CITY OF ALBUQUERQUE

RE: **4500 Canyon Court NE** (Single Family Residential)
Lot 36, Block 15, Glenwood Hills Unit 3
Grading & Drainage Plan for Building Permit

G23-D012

**4500 CANYON CT., NE
GRADING AND DRAINAGE PLAN**

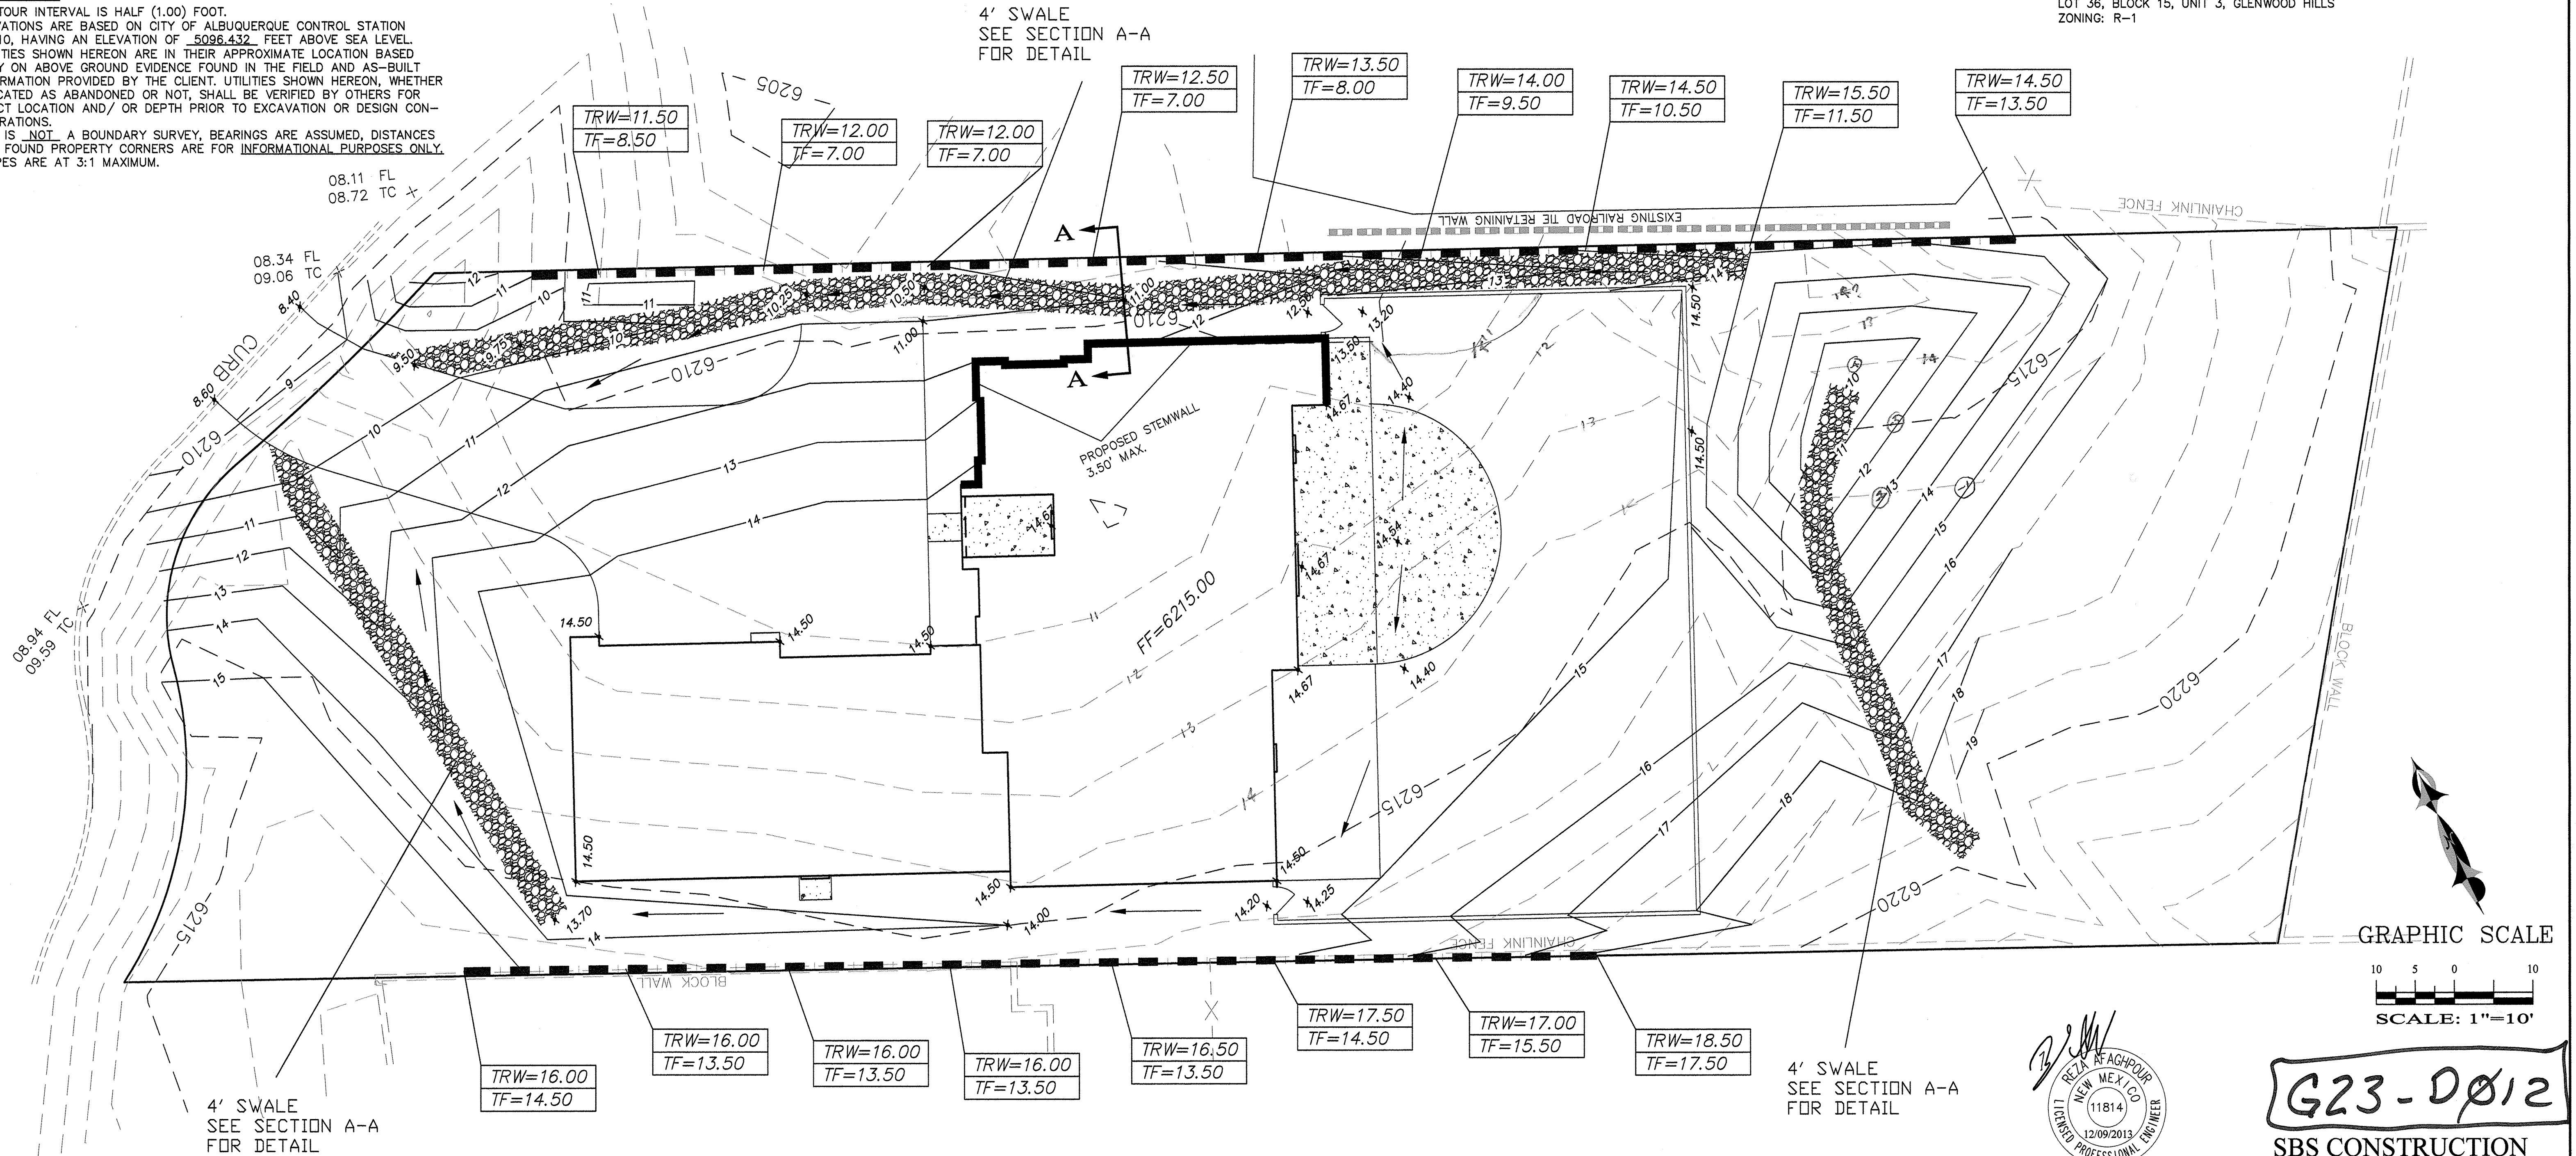
15.12 cfs off site
passing through

0.018% min slope
shown on plan

1' Depth shown on plan

Shawn,
Please recalculate with
correct channel slope to
confirm that it will
contain the 15.12 cfs.

Email revised ditch calcs
& I can approve G&D.
